REFERENCE: Arborist Response to City Review Comments RE: SUB22-009 (Cui Preliminary Short Subdivision)

SITE ADDRESS: 4833 90th Ave SE, Mercer Island, WA

DATE: 12/6/2023

This report addresses the City of Mercer Island's comments dated October 25, 2023.

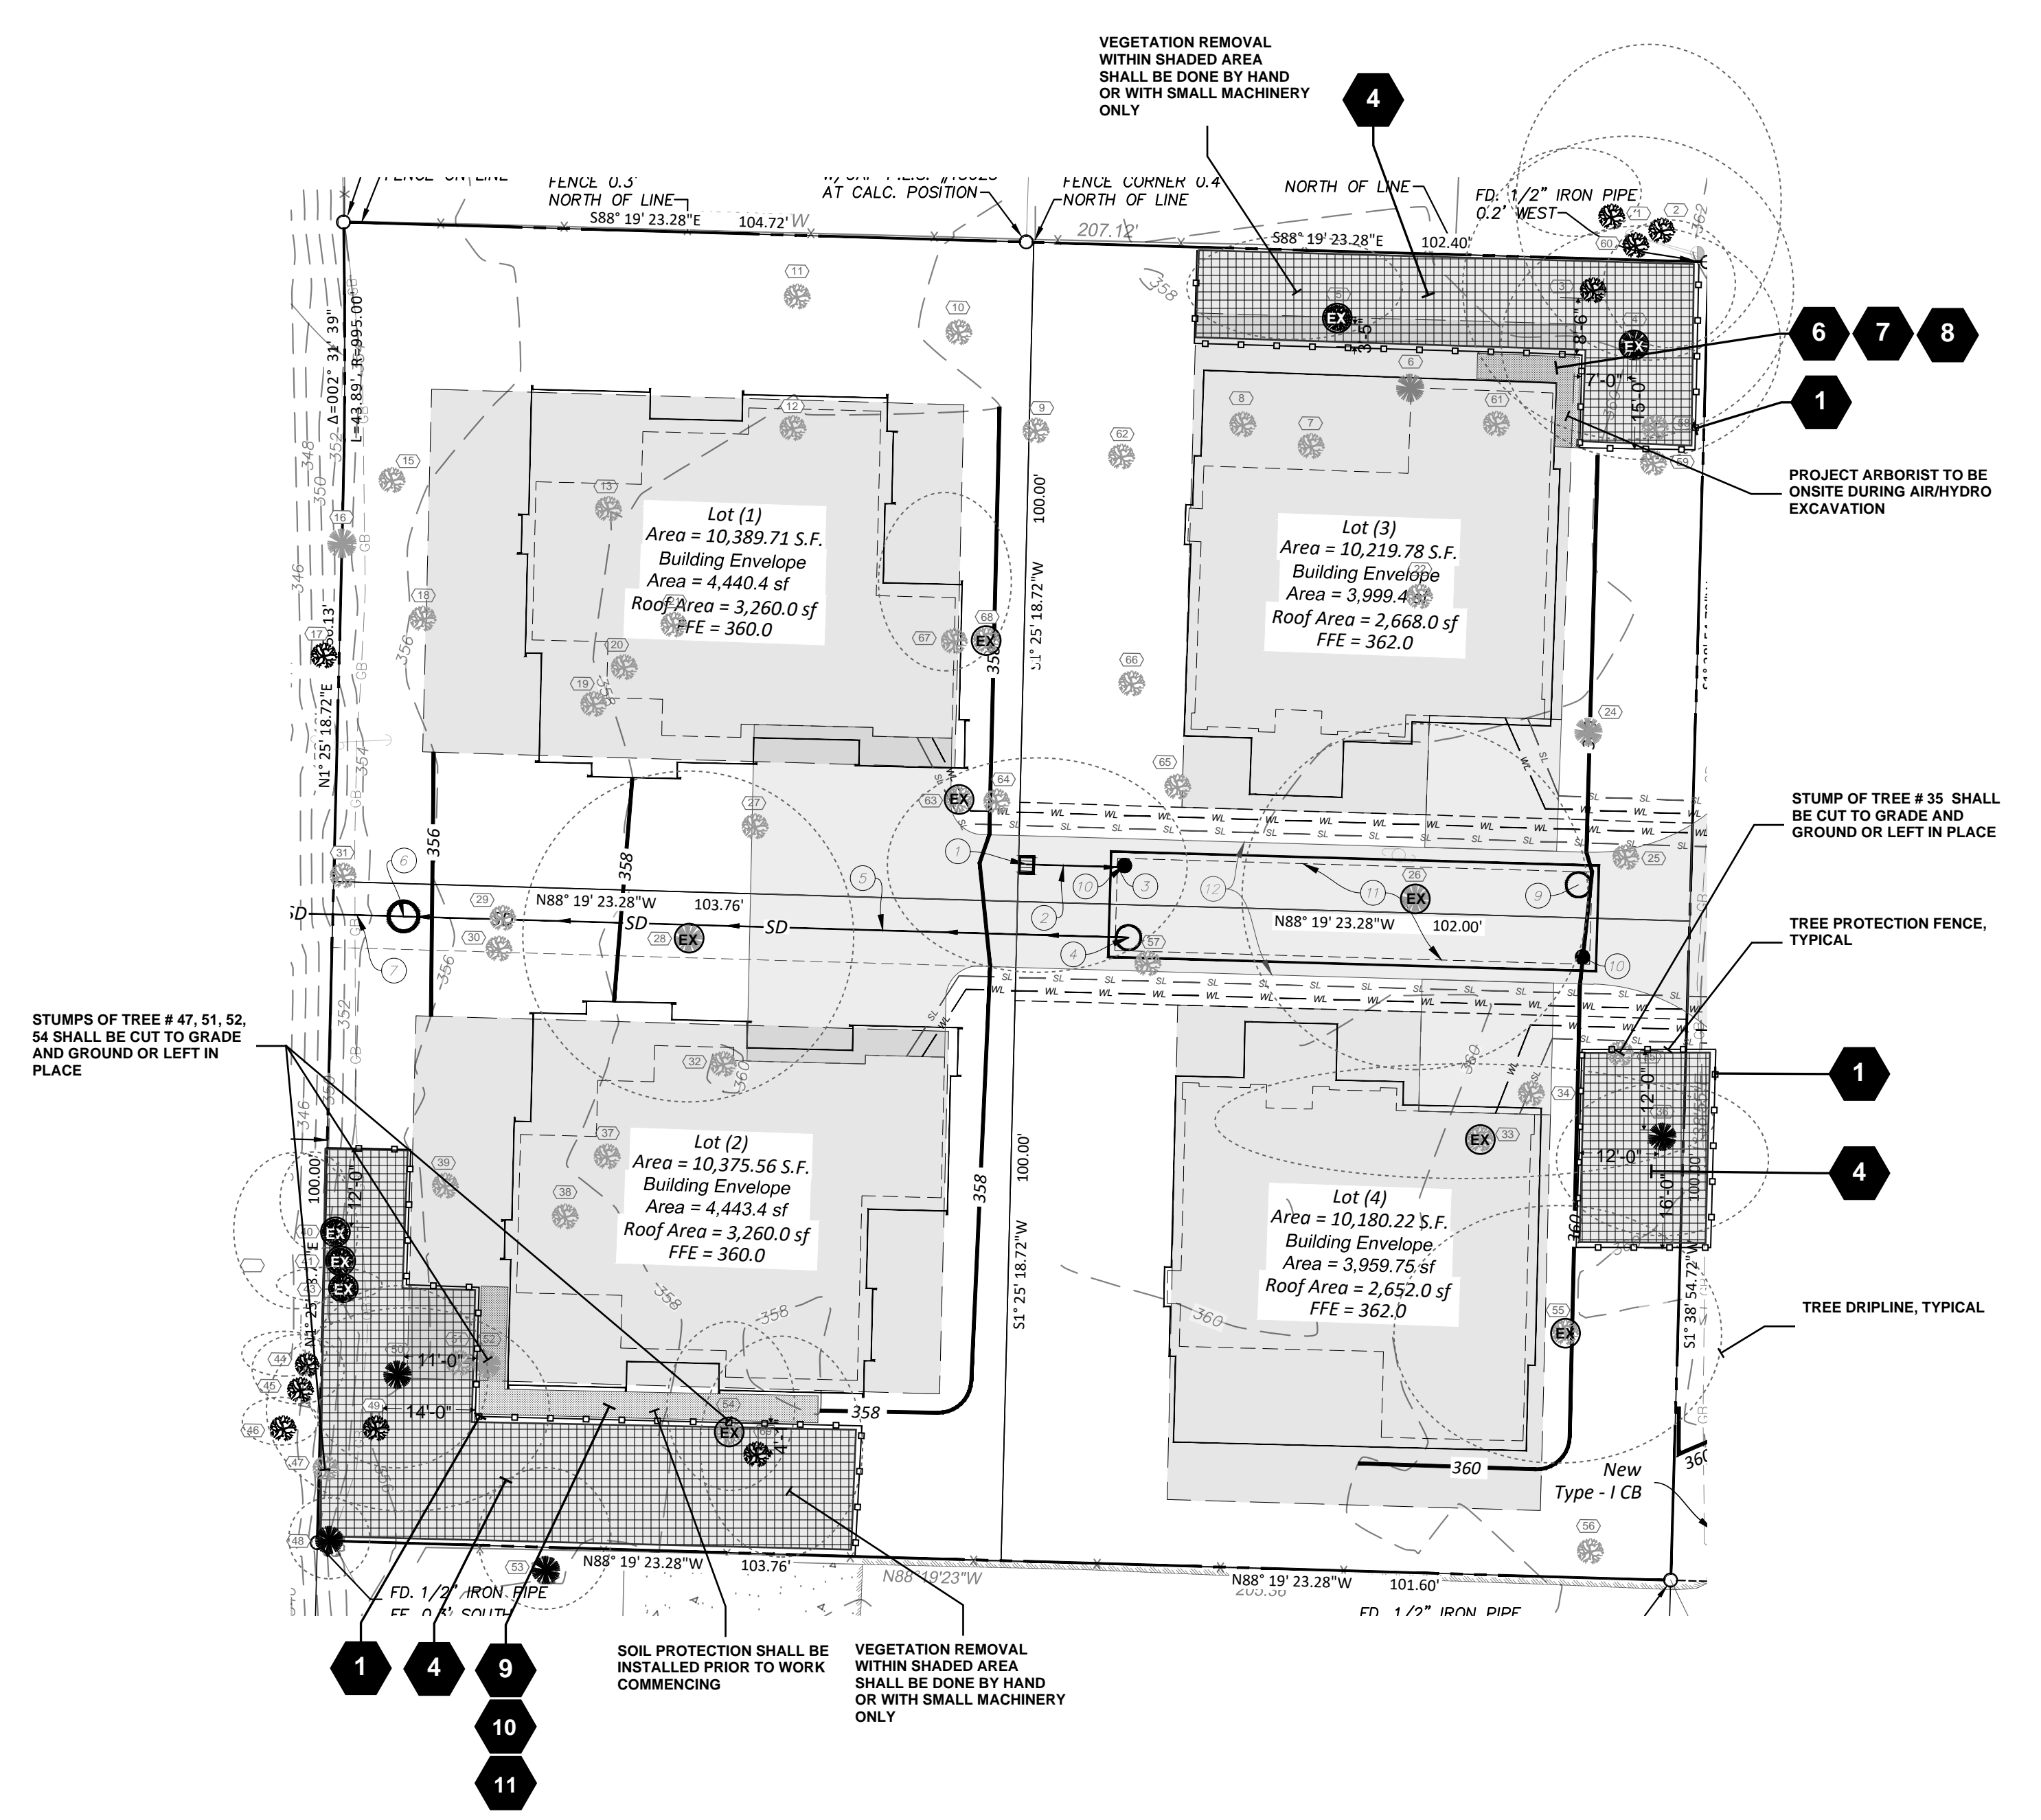
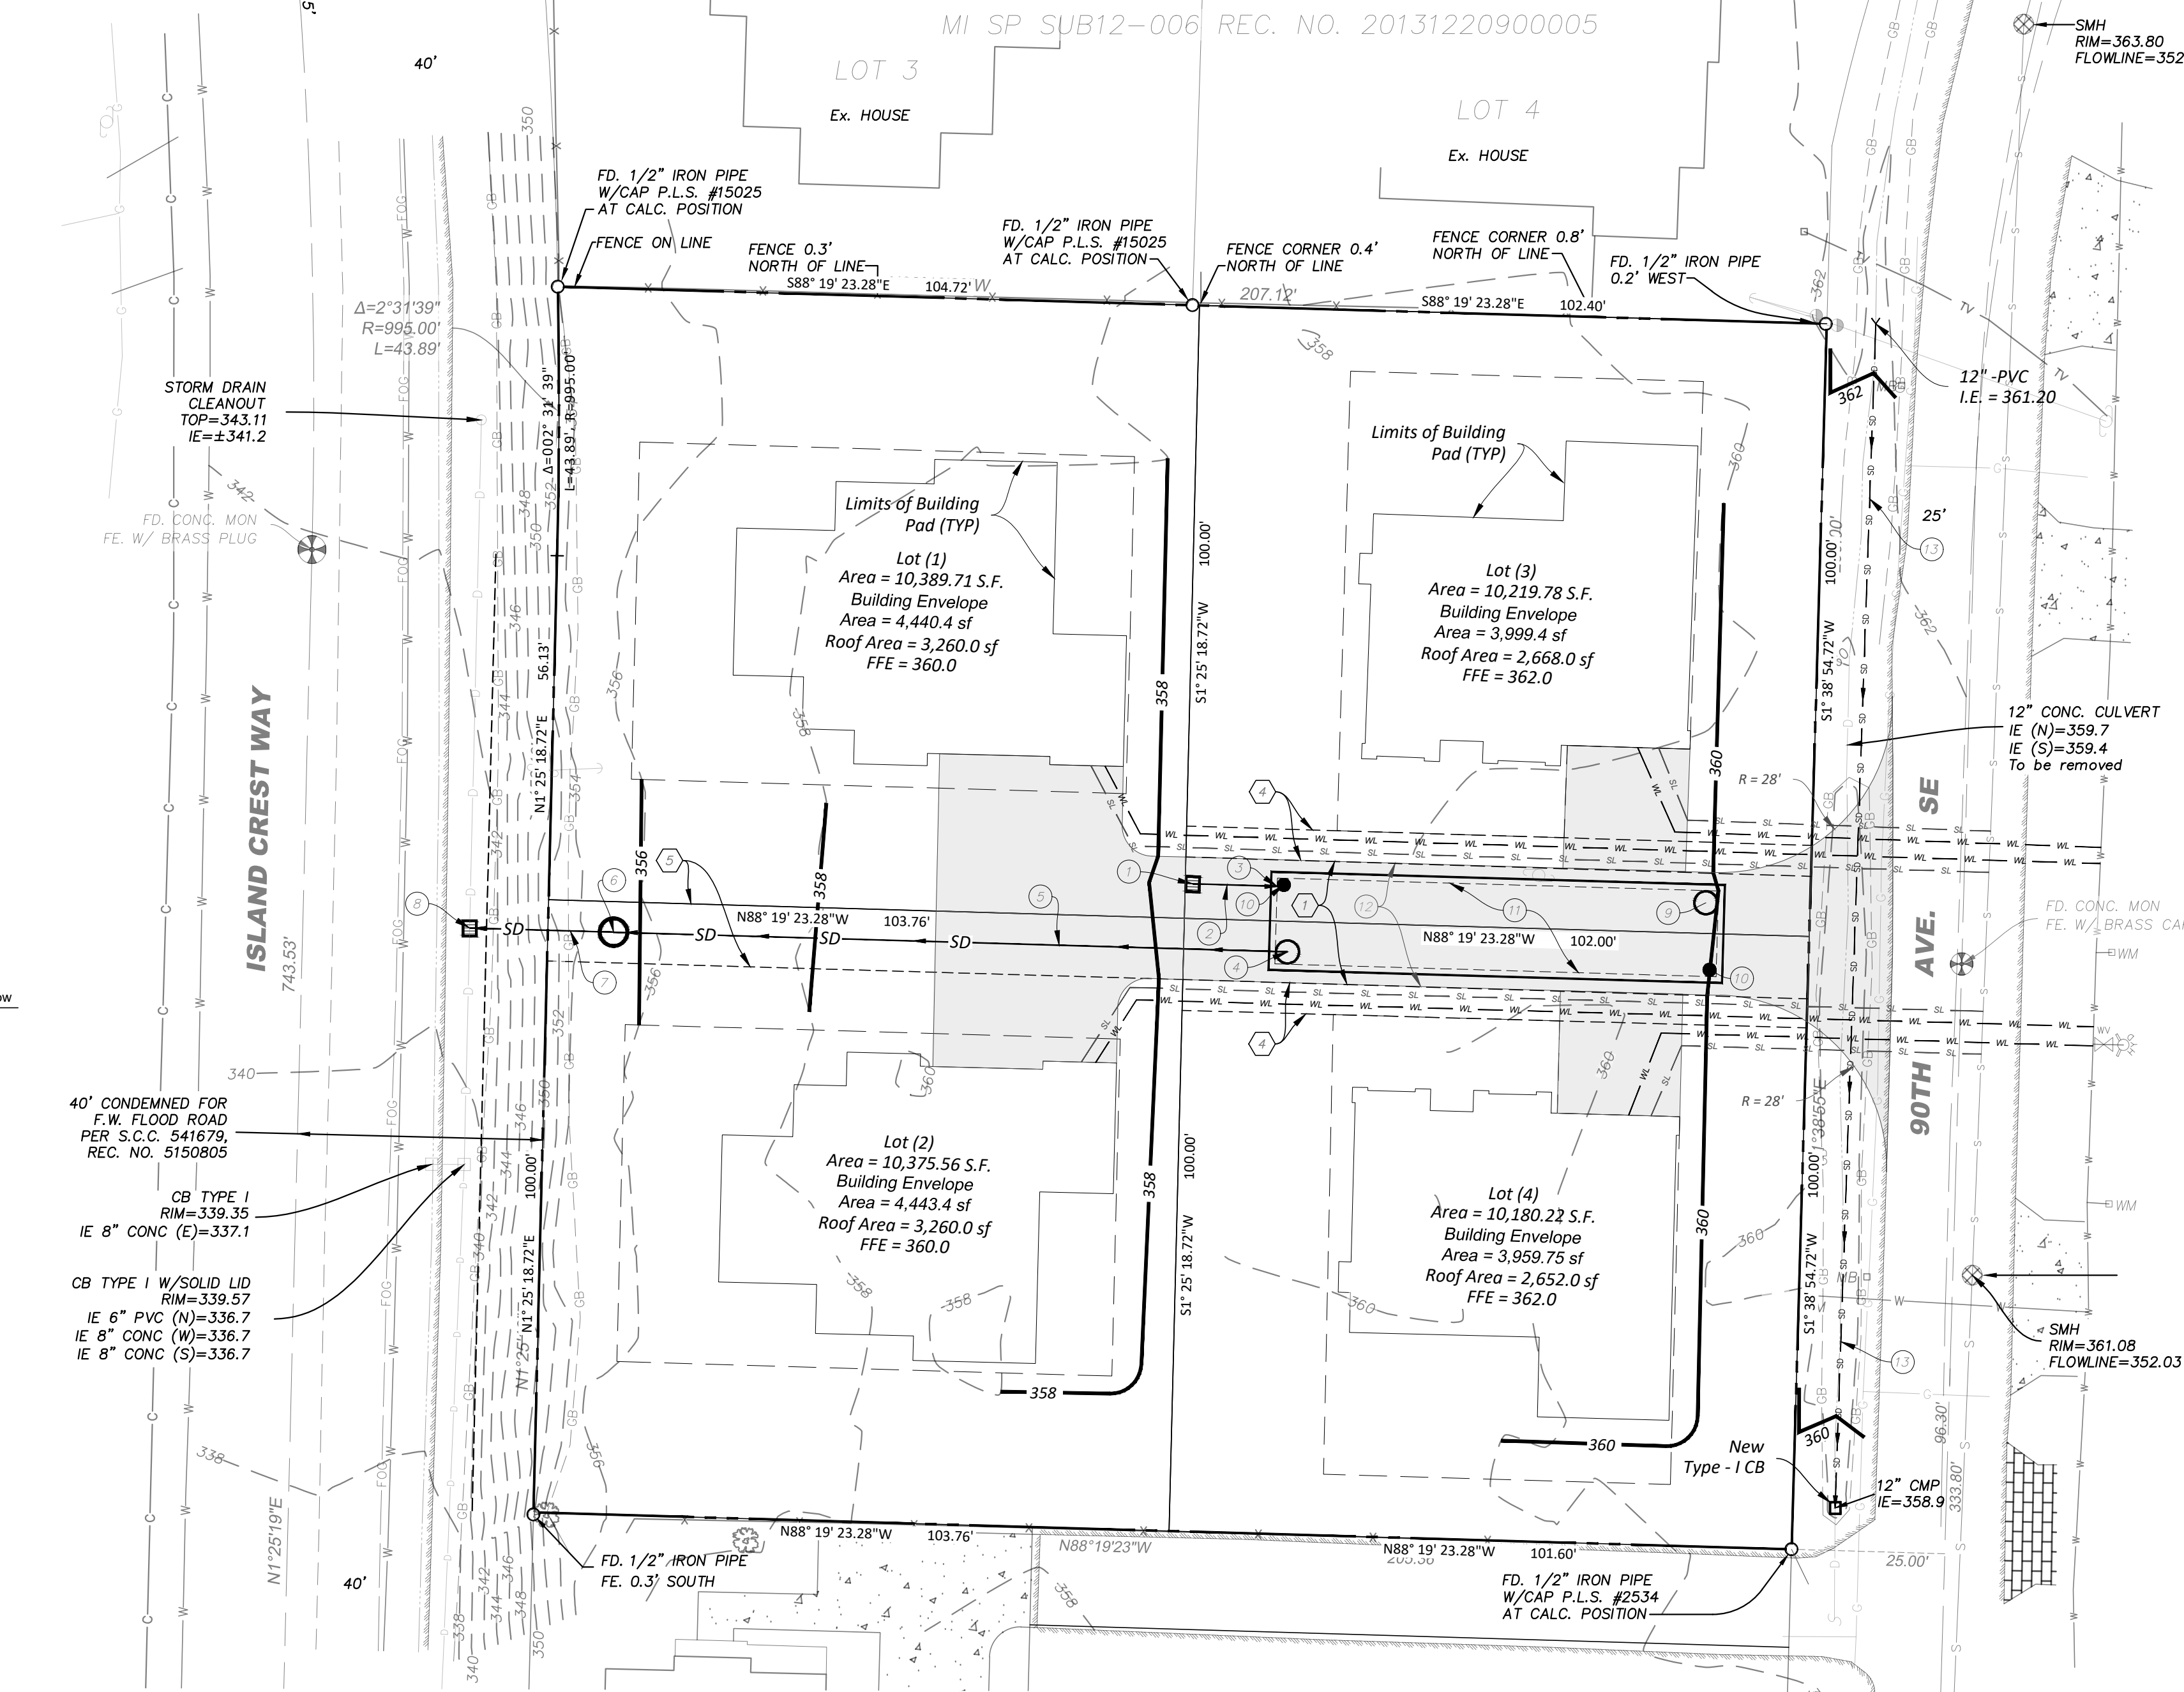
2. Please show an X through all trees proposed to be removed on the site plan. It is hard to see which trees are proposed to be removed on the current plan set. Marking each removed tree with an X will avoid mistakes during the site clearing phase.

4. The following trees are shown as retained, but not protected at their driplines: 3, 4, 5, 36, and 69. All retained trees must be protected in such a way that they will not be damaged and will remain viable long term. The trees may be considered removed if too many roots are damaged. Air excavation root analysis or other noninvasive techniques approved by the project shall be performed before any building pad location is approved. After the limits of allowable disturbance are determined by the project arborist, these limits must be included in the tree protection plan. Any excavation within the driplines of exceptional trees or other trees required for retention can only be performed if they will not be damaged as per MICC 19.10.080. The project arborist must discuss this code and the long-term viability/stability of the trees after the proposed excavation within the dripline area.

Arborist Response: Completed. See the revised Tree Retention Plan dated 12/4/2023, Sheet TR-01.

Arborist Response: Tree #s 3, 4, 5, 36, 54 and 69 are now protected at their driplines. See the revised Tree Retention Plan dated 12/4/2023, Sheet TR-01.
